EL PASO COUNTY GRADING AND EROSION CONTROL PLAN CHECKLIST

EPC Project Number:

CE1.2

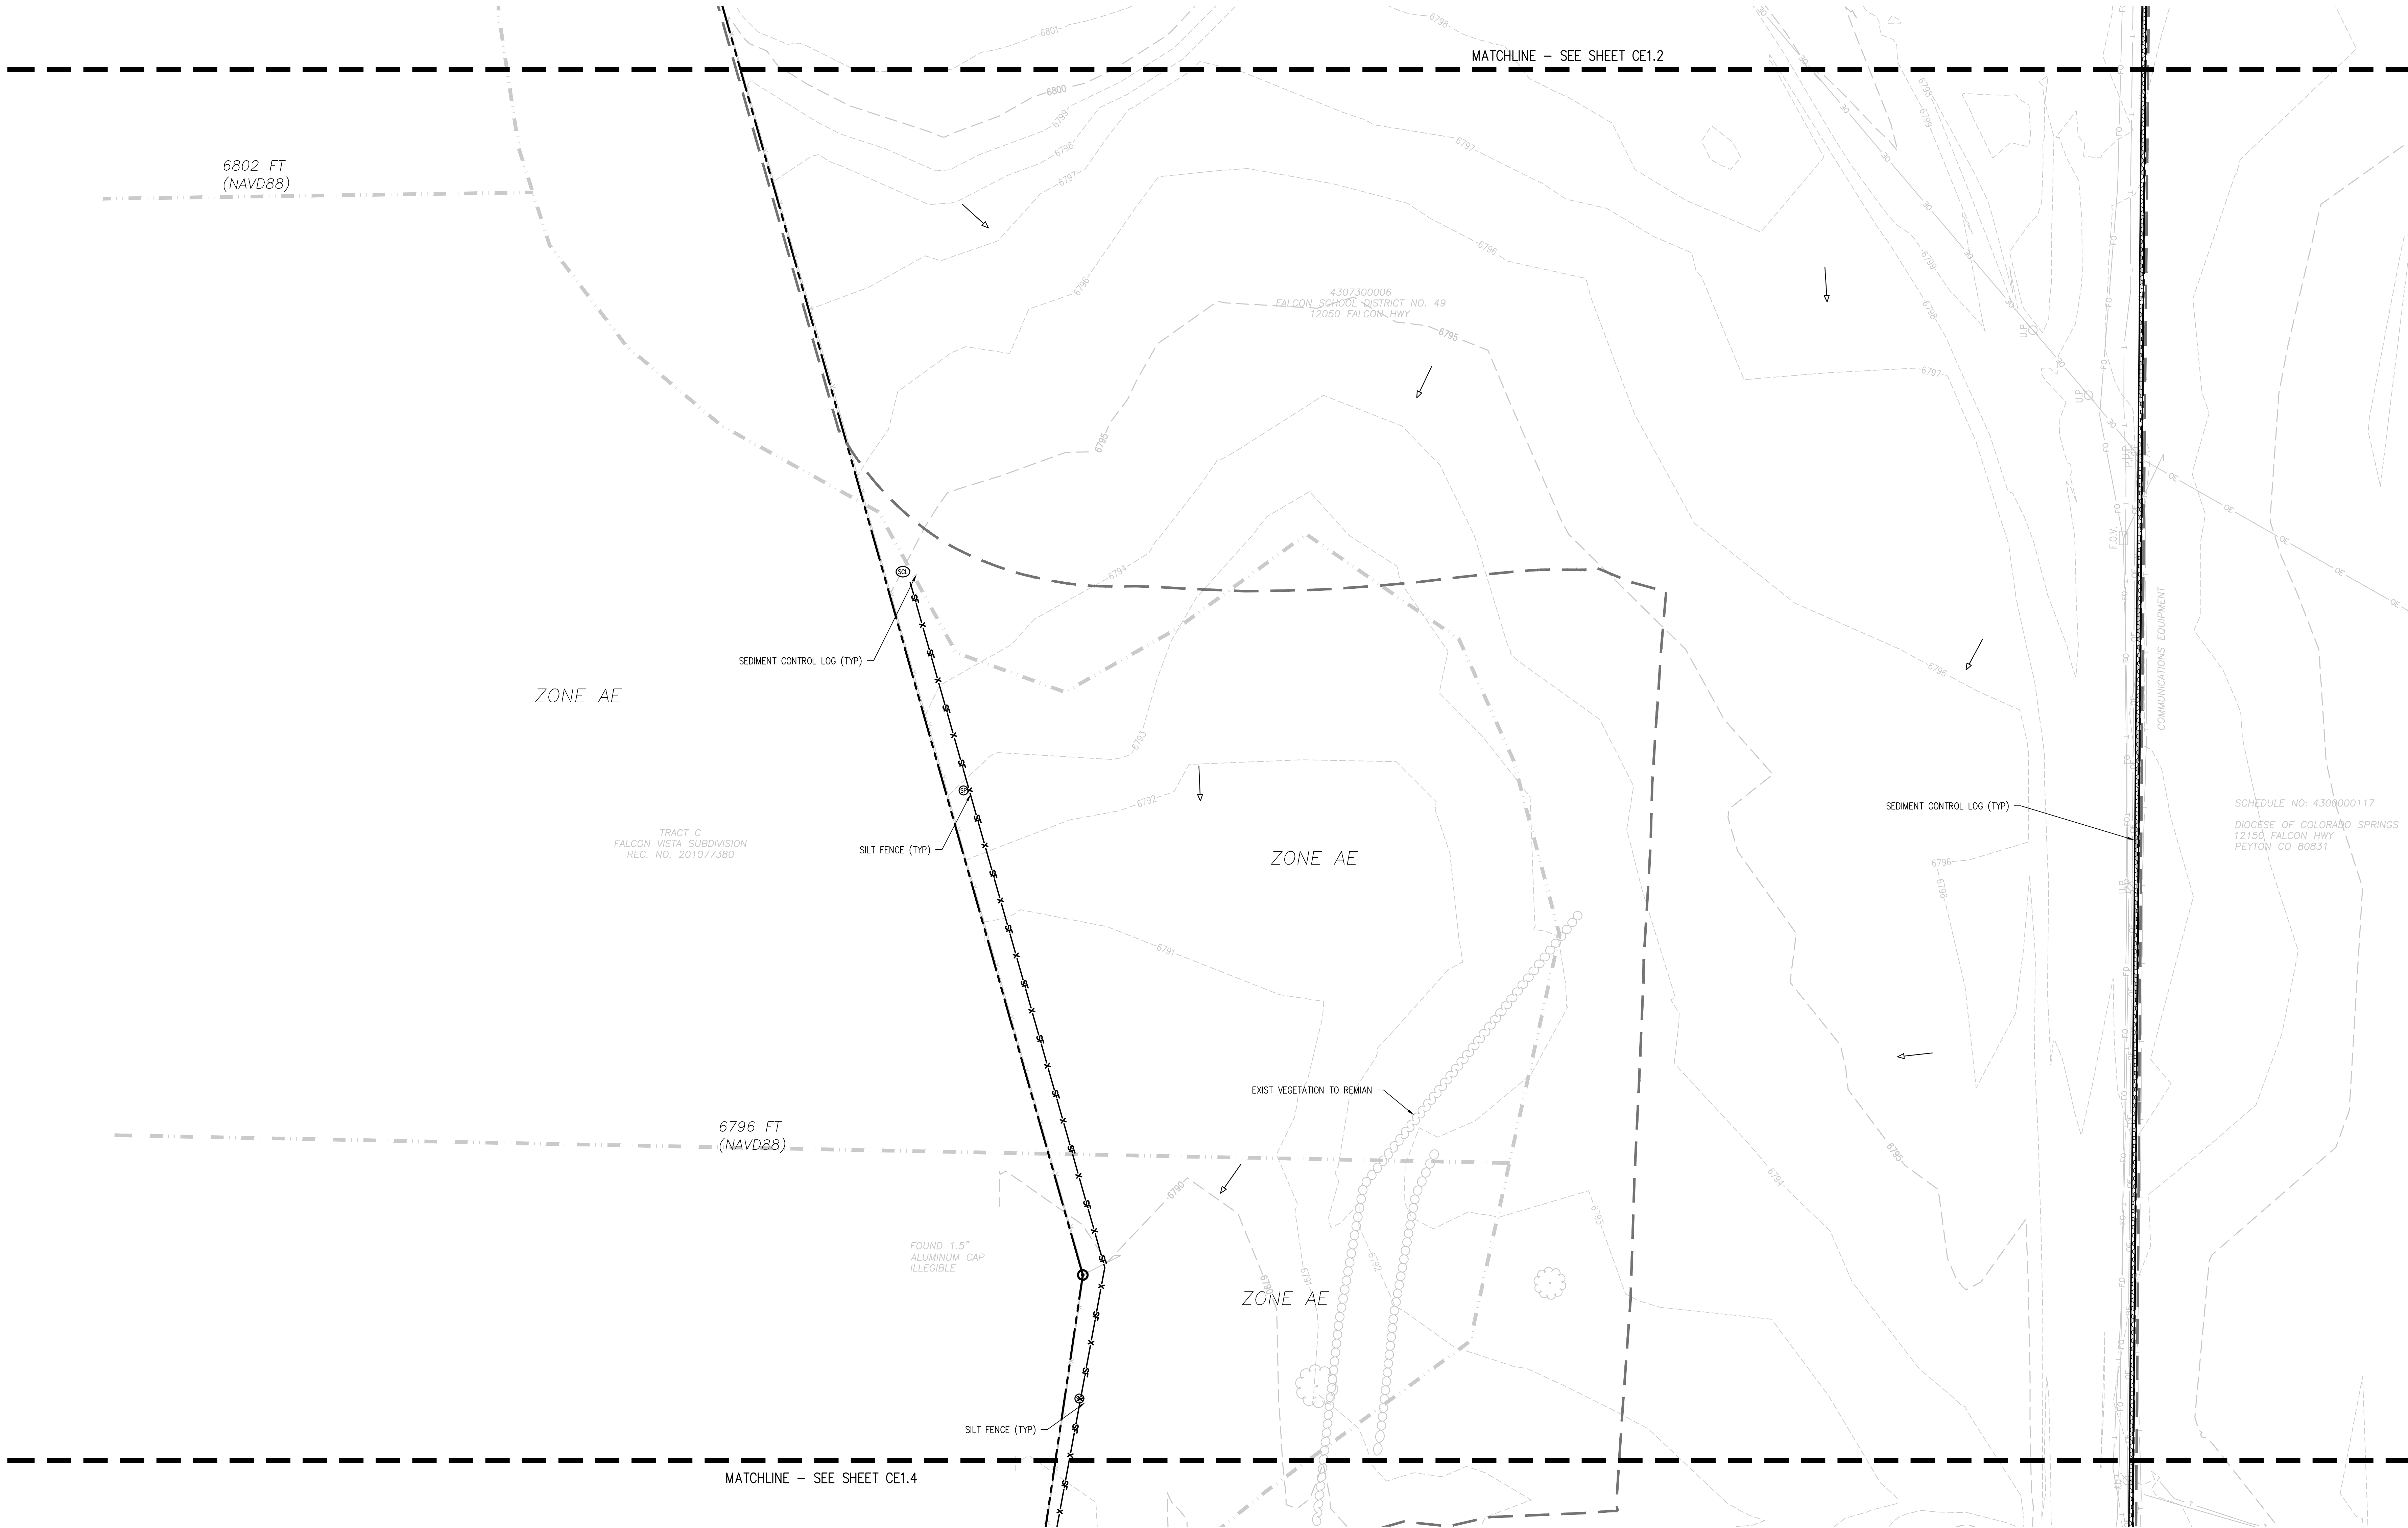
v	All proposed temporary construction control measures, structural and non-structural. Temporary construction control measures shall be identified by phase of implementation to include "initial," "interim," and "final" or shown on separate phased maps identifying each phase		✓
w	Vehicle tracking provided at all construction entrances/exits. Construction fencing, barricades, and/or signage provided at access points not to be used for construction		✓
x	Temporary sediment ponds provided for disturbed drainage areas greater than 1 acre		✗
